## *Rezoning Petition Review*

**Rezoning Petition #:** 08-65

**Proposed Zoning:** MUDD-O

**Location of Property:** Approximately 9.02 acres located on both sides of Providence Road at Oxford Place

01-28-08
AS NOTED
EAST CAMPUS
SITE PLAN
BUFFER INFO.

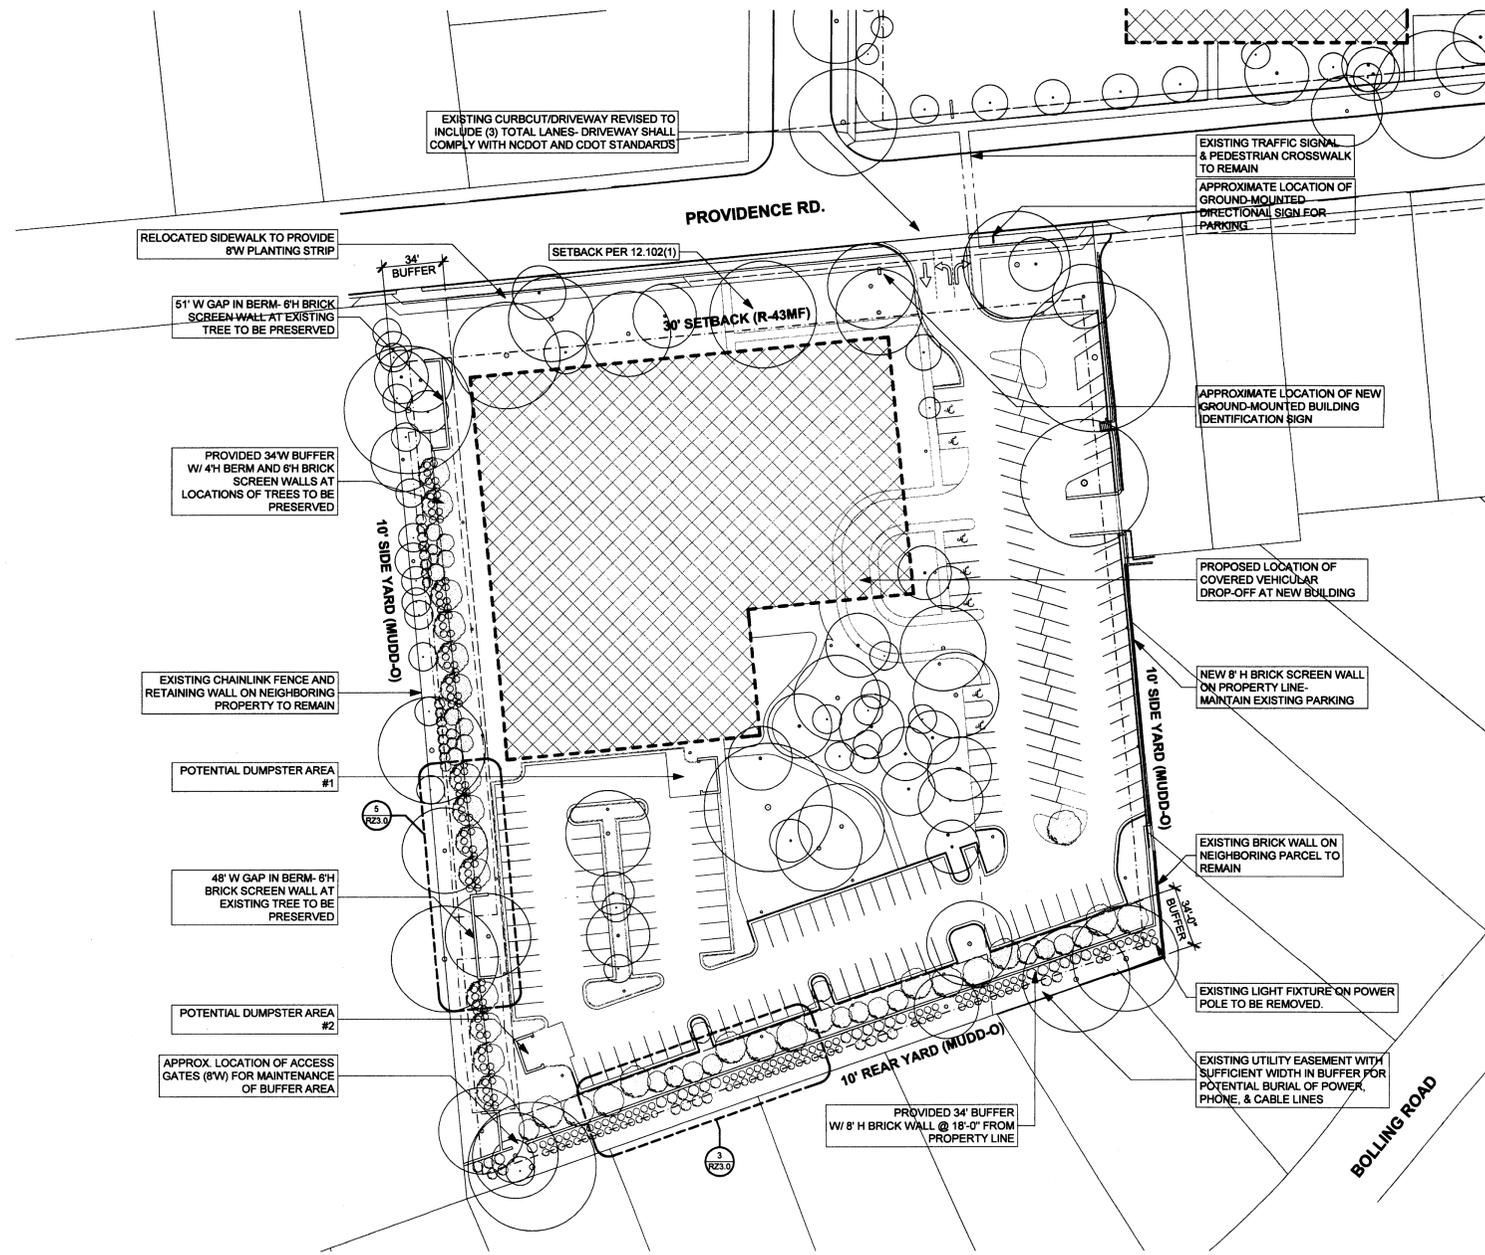
**Concerning Storm Water:** Please add the following notes under "14. Storm Water Management & Water Quality"

The following shall be applicable to the East Campus portion of the rezoning petition:

Storm Water Quality Treatment:

For projects with defined watersheds greater than 24% built-upon area, construct water quality best management practices (BMPs) to achieve 85% Total Suspended Solid (TSS) removal for the entire post-development runoff volume for the runoff generated from the first 1-inch of rainfall. BMPs must be designed and constructed in accordance with the Mecklenburg County BMP Design Manual, July 2007 or North Carolina Division of Water Quality Storm Water Best Management Practices Manual, July 2007. (Design Standards shall be met according to the City of Charlotte Best Management Practices Manual, when available). Use of Low Impact Development (LID) techniques is optional.

Volume and Peak Control:

For projects with defined watersheds greater than 24% built-upon area, control the entire volume for the 1-year, 24-hour storm. Runoff volume drawdown time shall be a minimum of 24 hours, but not more than 120 hours.

For commercial projects with greater than 24% BUA, control the peak to match the predevelopment runoff rates for the 10-yr, 6-hr storm and perform a downstream flood analysis to determine whether

additional peak control is needed and if so, for what level of storm frequency, or if a downstream analysis is not performed, control the peak for the 10-yr and 25-yr, 6-hour storms.

For commercial projects with less than or equal to 24% BUA, but greater than one acre of disturbed area, control the peak to match the predevelopment runoff rates for the 2 and 10-yr, 6-hr storm.
